WRITTEN SUMMARY OF THE ORAL CASE PUT BY THE MARINE MANAGEMENT ORGANISATION AT THE ISSUE SPECIFIC HEARING ON MARINE MATTERS

- 1.1 This is the written summary of the oral case that was put by the Marine Management Organisation (“MMO”) at the issue specific hearing into marine matters for the proposed Able Marine Energy Park (“AMEP”) which took place on 13 September 2012.
- 1.2 Only those issues or topics on which the MMO made submissions at the hearing are included below. It should be noted that the summary of the oral case put by the MMO at the issue specific hearings into the compensation site, main site and associated HRA matters on 11 and 12 September 2012 is contained in a separate document.

Figure 16 Transects showing model predicted sedimentation along intake/outfall lines (Model Run 43)

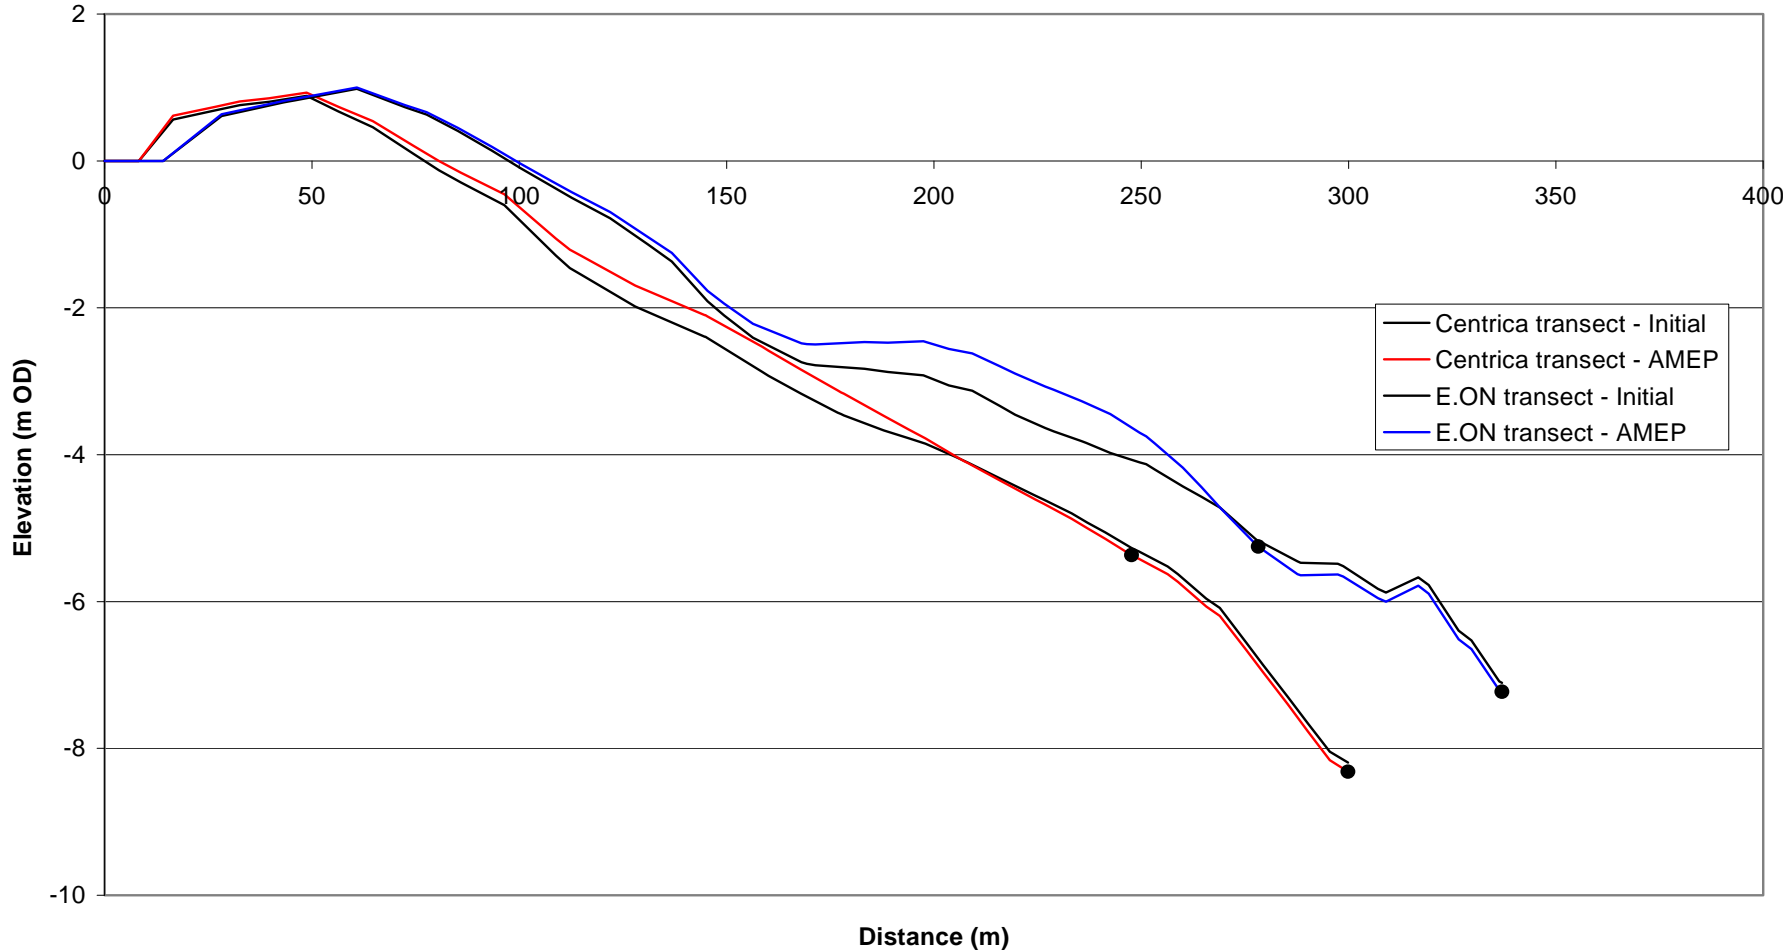
- 2.1 In light of the fact that the works undertaken at the AMEP site are likely to result in the E.ON and Centrica Outfalls silting up, a mechanism needs to be agreed as to how to address that siltation. Initially two options were presented by the Applicant:
 - (i) maintenance dredging the outfalls;
 - (ii) moving one or both of the outfalls.
- 2.2 Throughout all stages of this application the MMO has made it clear that the Applicant should decide which option it wishes to pursue as it will require inclusion in the Deemed Marine Licence (“DML”) at Schedule 8 of the proposed Development Consent Order (“DCO”) and the MMO is of the opinion that it is not appropriate to licence both options simultaneously.

- 2.5 At the hearing the MMO also noted that the increase in suspended material at the intake valves of the E.ON and Centrica outfalls was of concern and that the Applicant has proposed real-time monitoring of the suspended sediment concentration near the intakes. The MMO highlighted that a monitoring and mitigation strategy to assess, and where required mitigate any changes must be agreed in writing with the MMO prior to any works commencing and that a condition to this effect will need to be included in the DML. The development of such a strategy will require consultation with E.ON and Centrica to ensure suitable management trigger thresholds are development. No details concerning that monitoring and mitigation strategy have been received from the Applicant to date.
